P 13/14/NMA

Application for a non-material amendment following a grant of planning permission.
Town and Country Planning Act 1990

Proposed dwelling to replace existing dwelling

P/61/12

DATE	September 2012	DRAWN	PT
DRAWING NUMBER	12020/005	REVISION	E

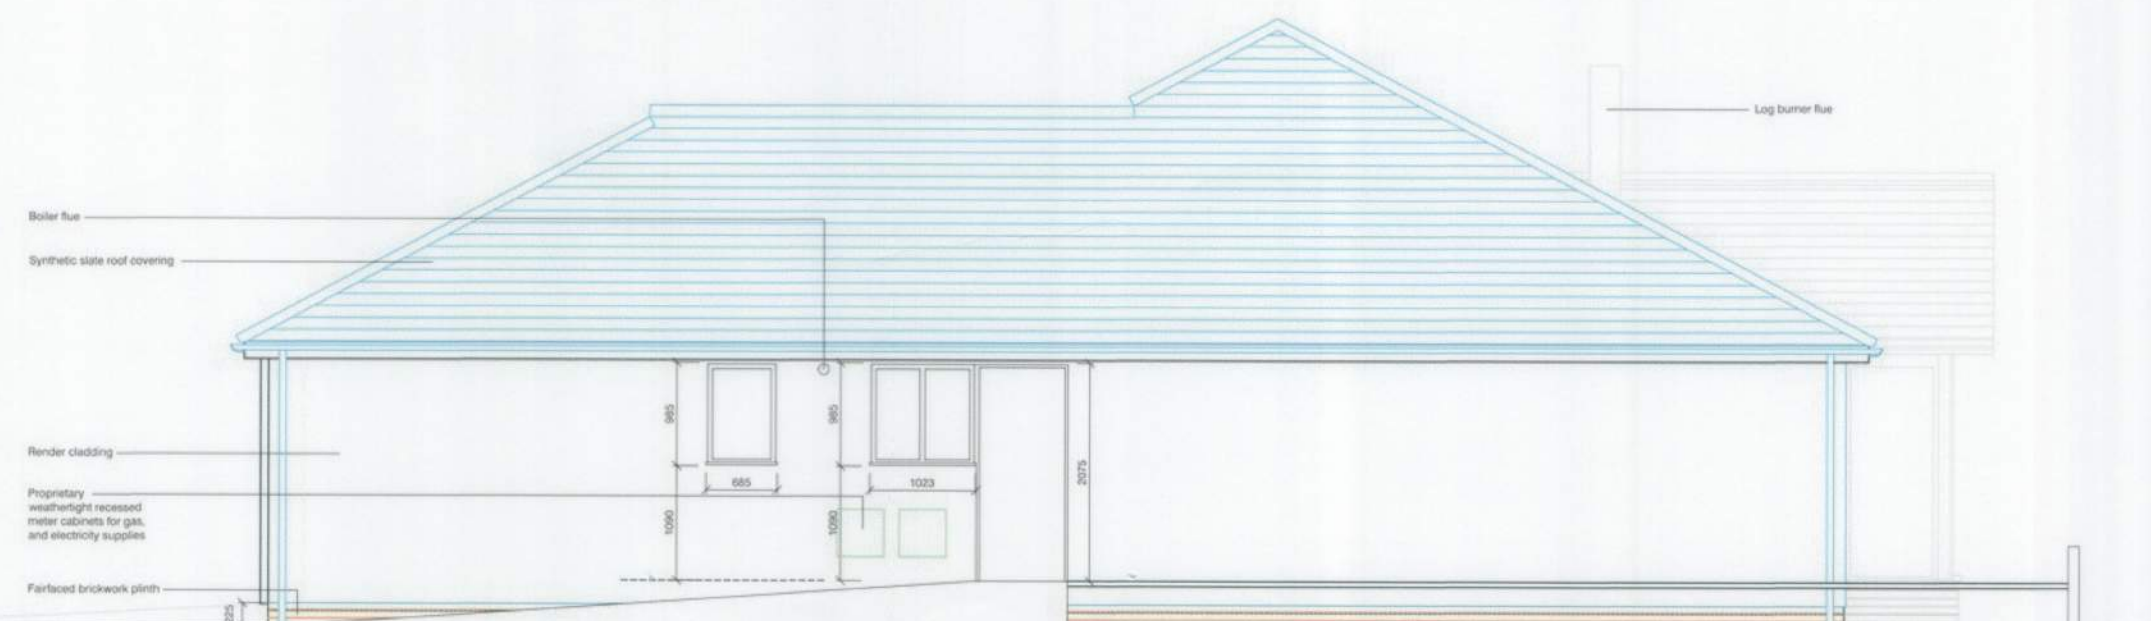
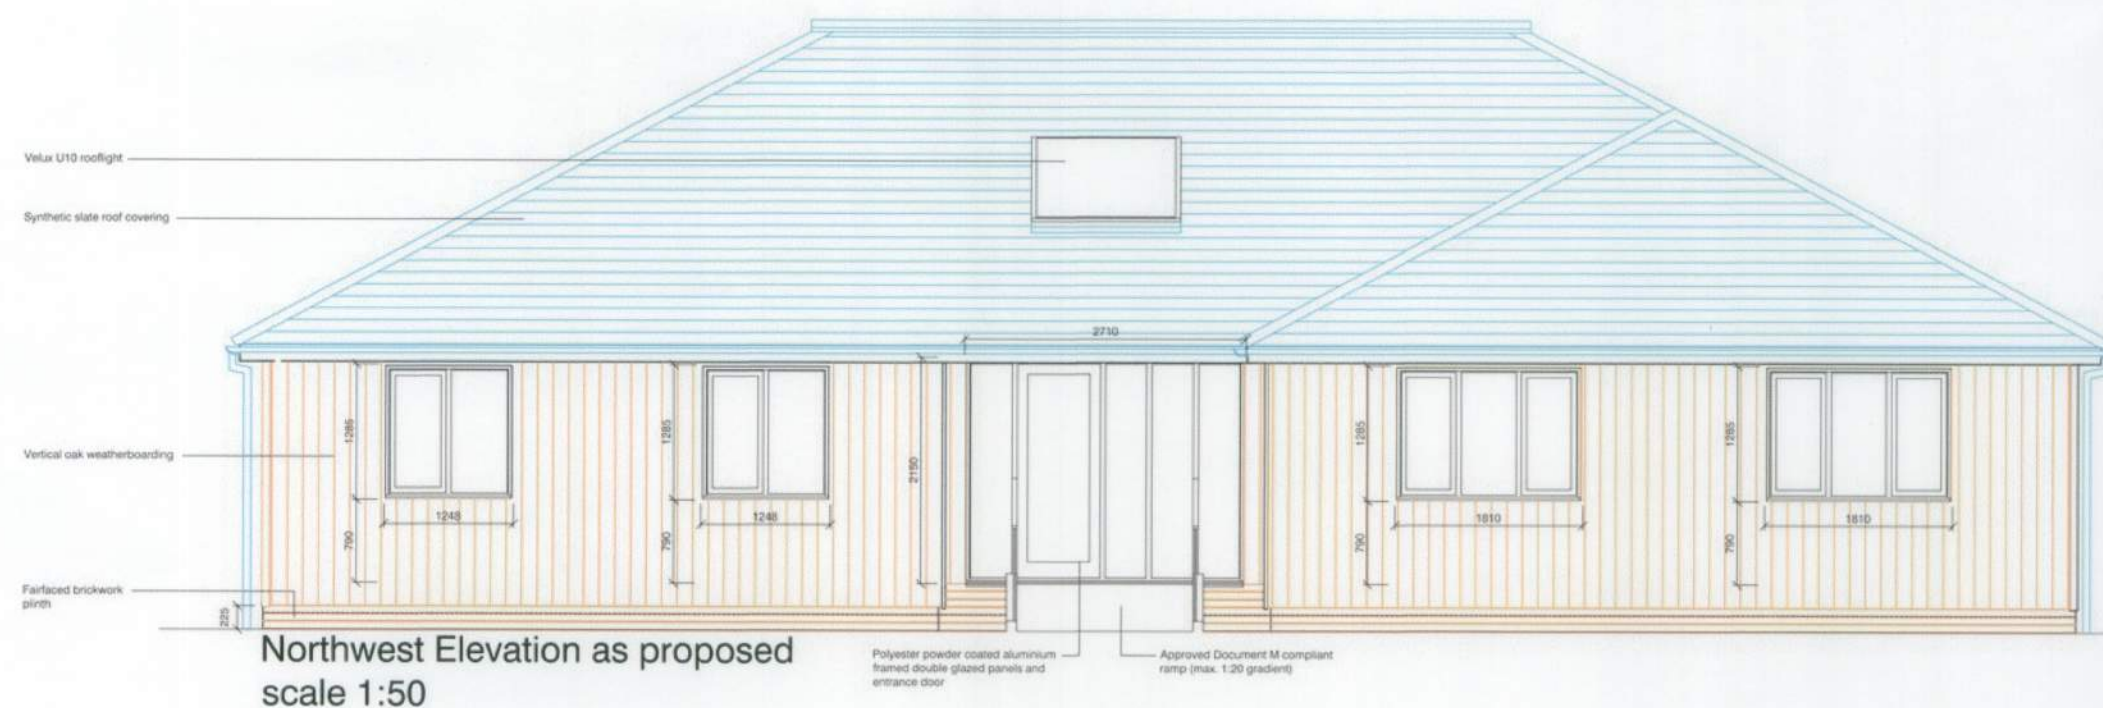
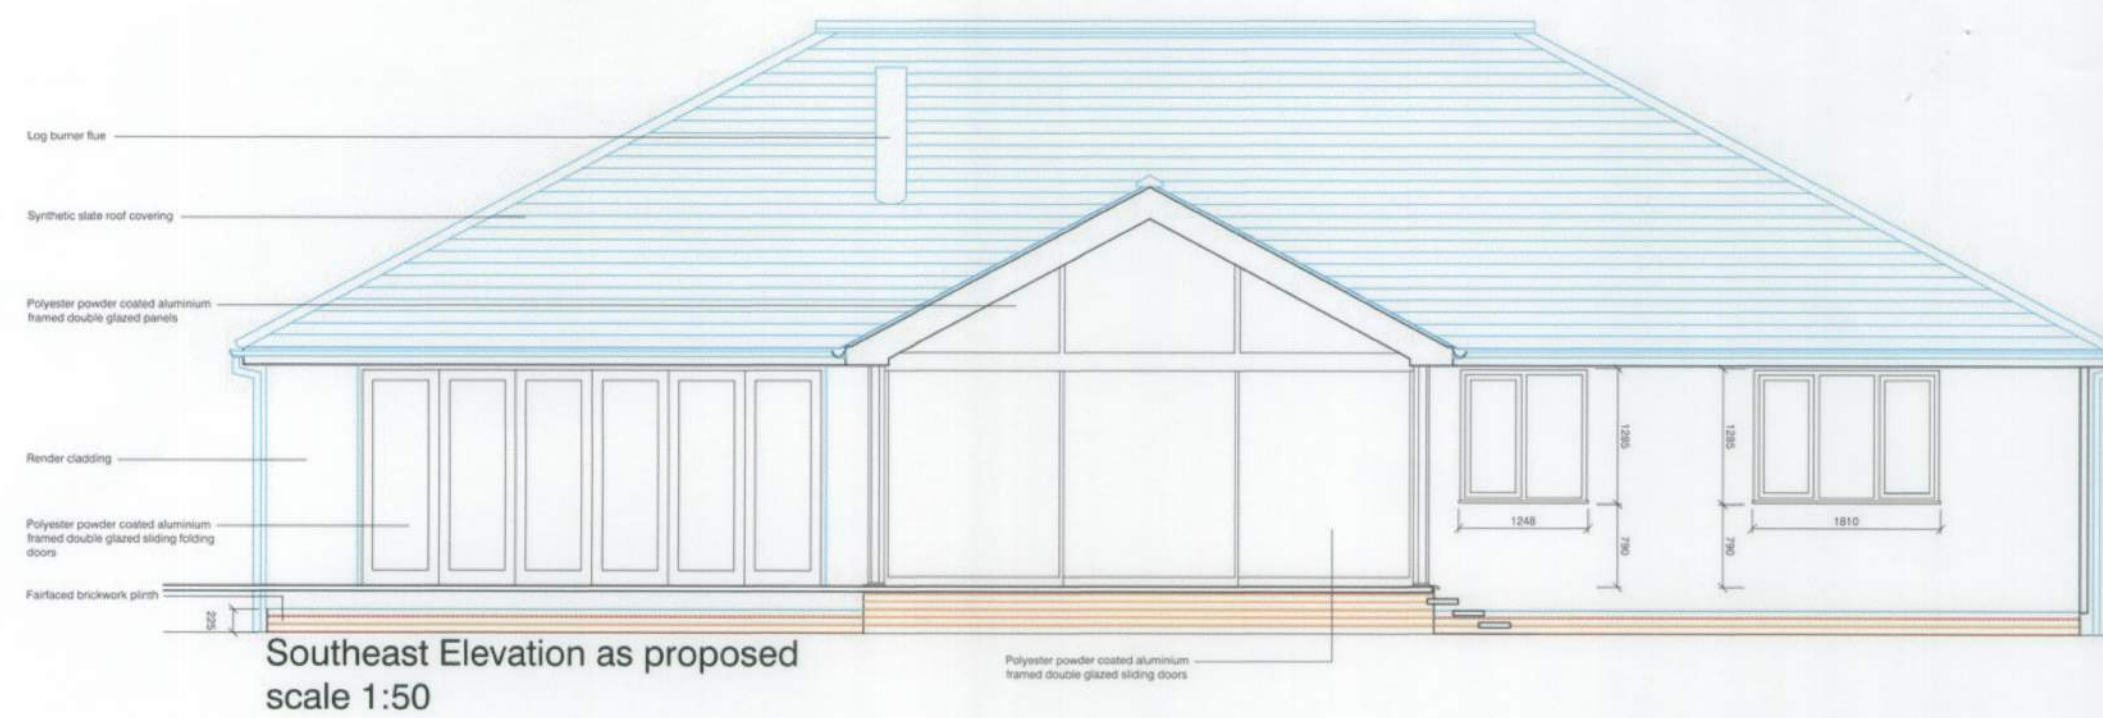
Addition of solid, unglazed side door to provide external access to/from Utility Room.
Addition of small window with obscured glass to Southwest elevation, to provide natural light to en-suite.
Window and door to match other fenestration.
